Addendum No. 2

RE: Contract # C203977

Johnston County (I-5781)

I-40 From SR-1010 (Cleveland Road) To West of SR-1211 (Morgan Road)

TIP NO.	SHEET NO.
I-5781	PMP-2
APPROVED: <i>Joseph B. Kopaskie</i>	
DATE: 10/6/2017

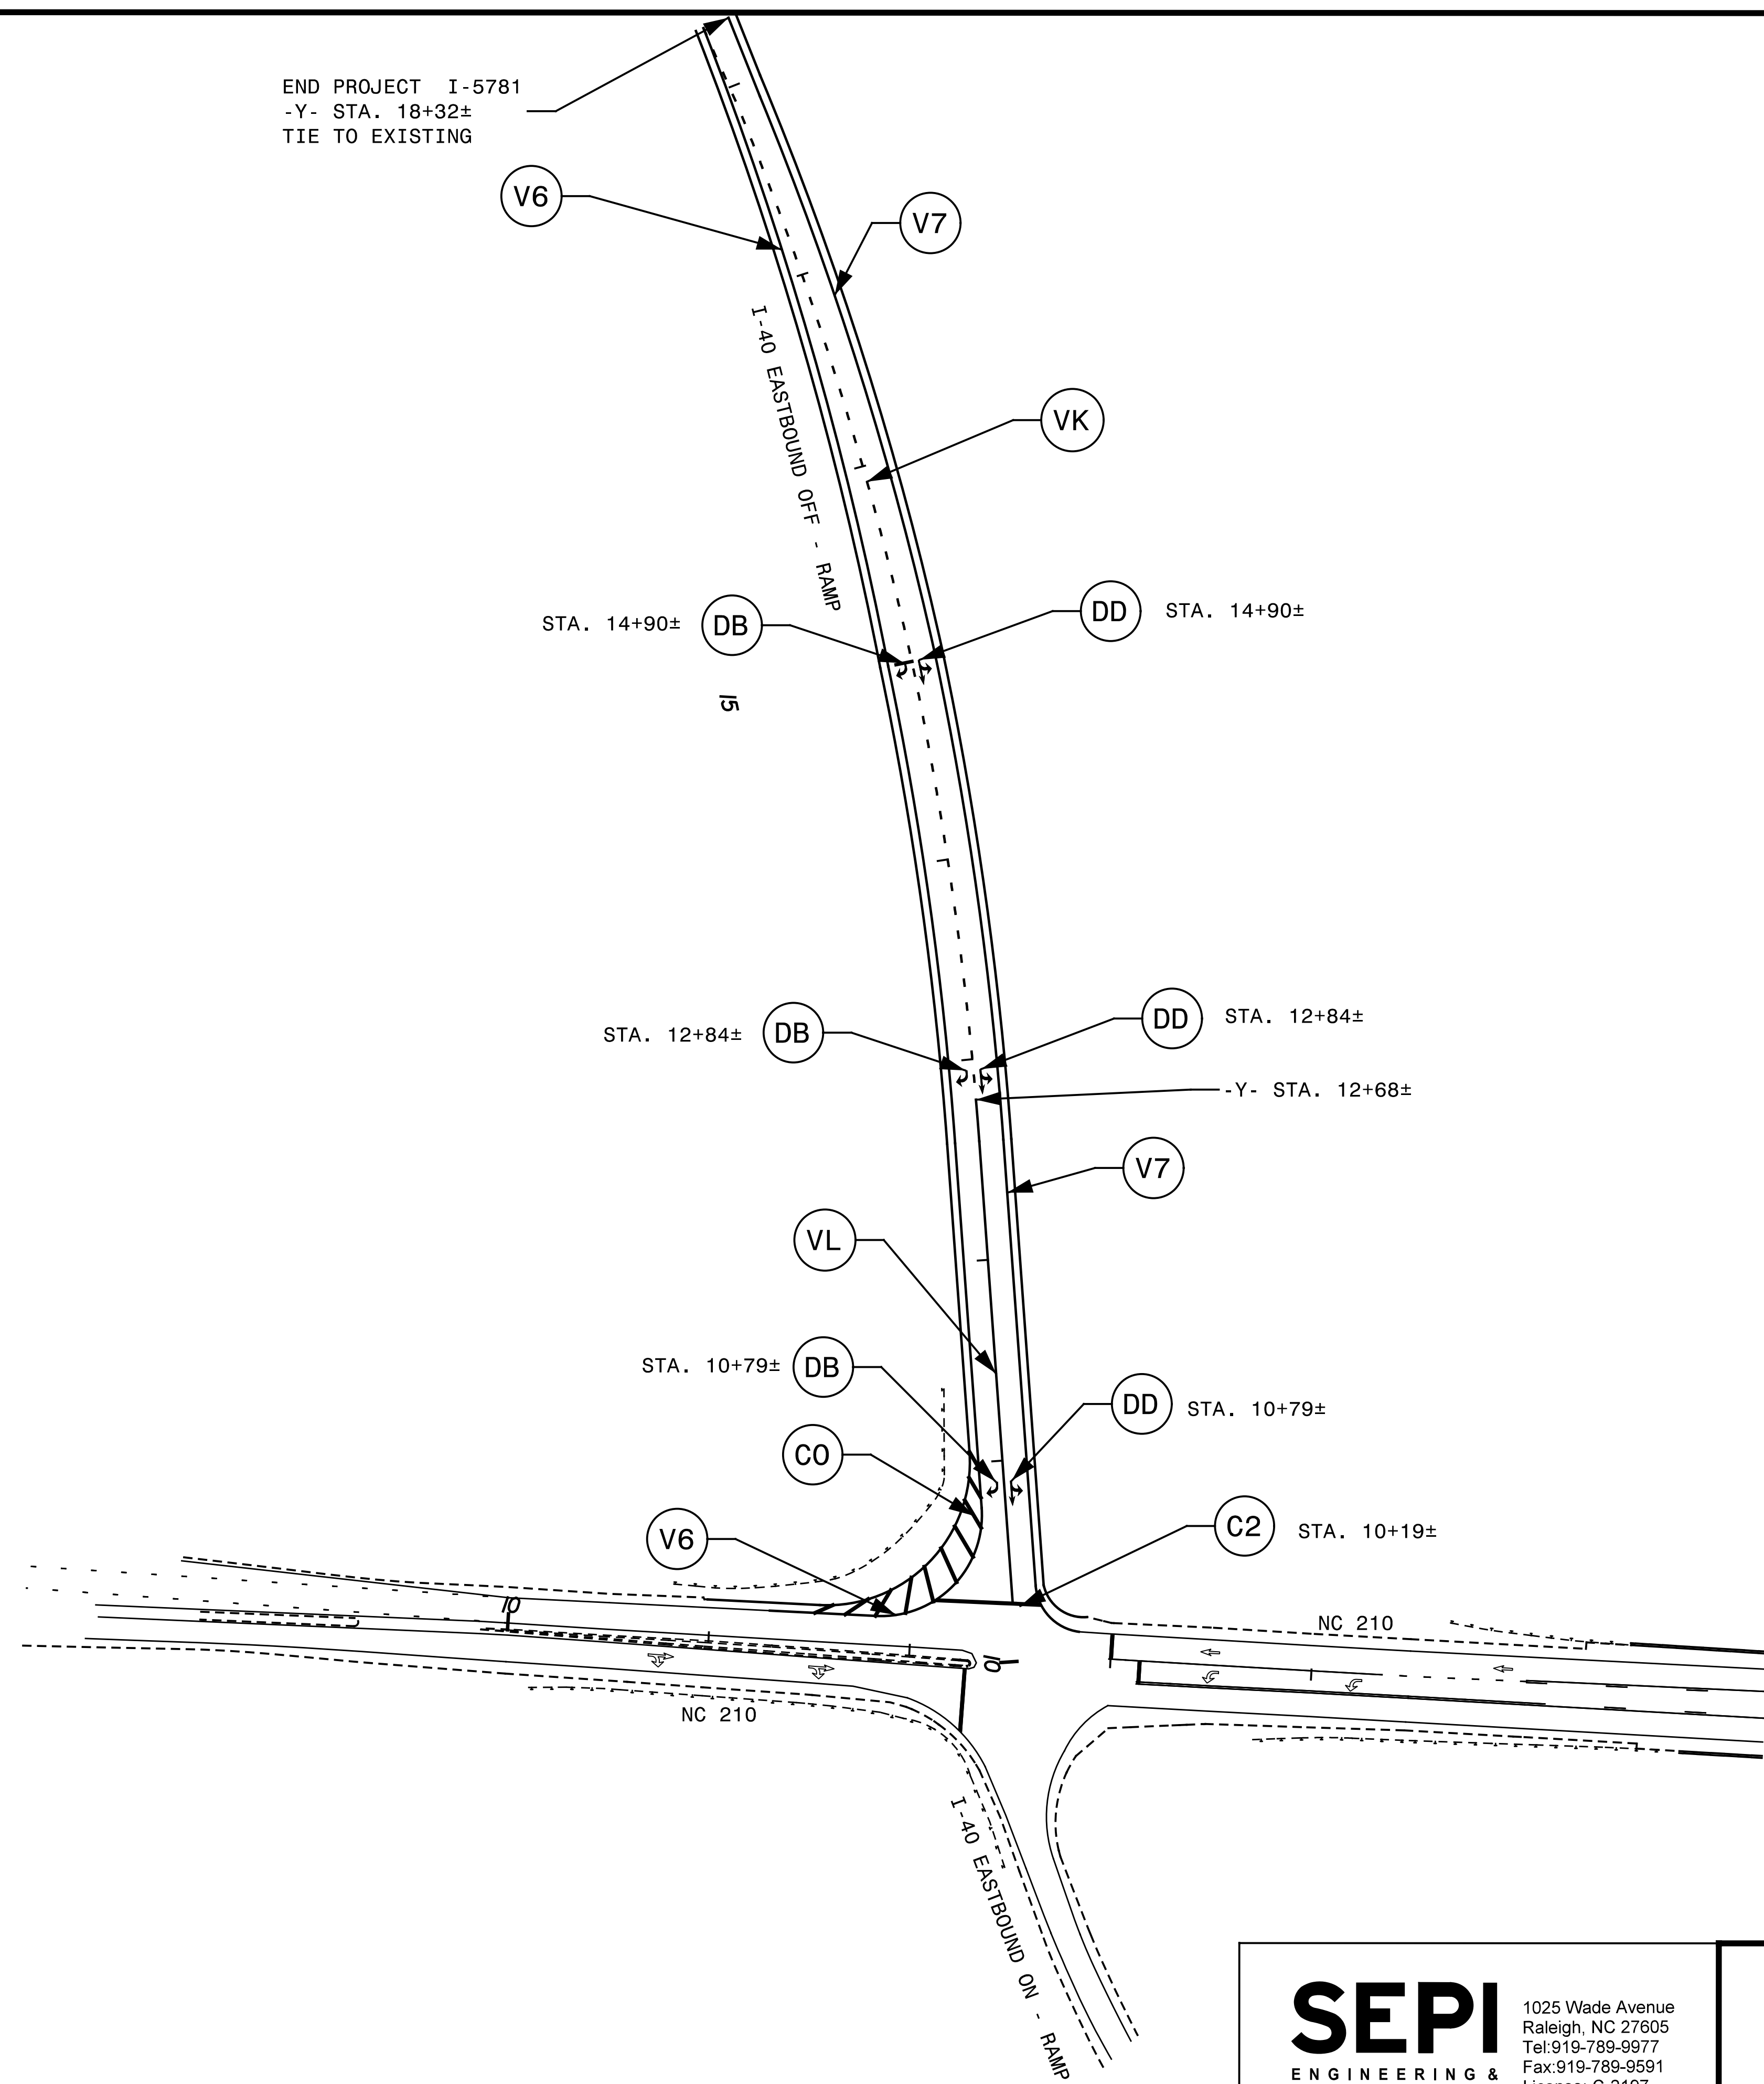
Sheet No.	Revisions
PMP-1 and PMP-2 (second revision)	Revised to reflect the change in pavement markings as noted in Addendum #1
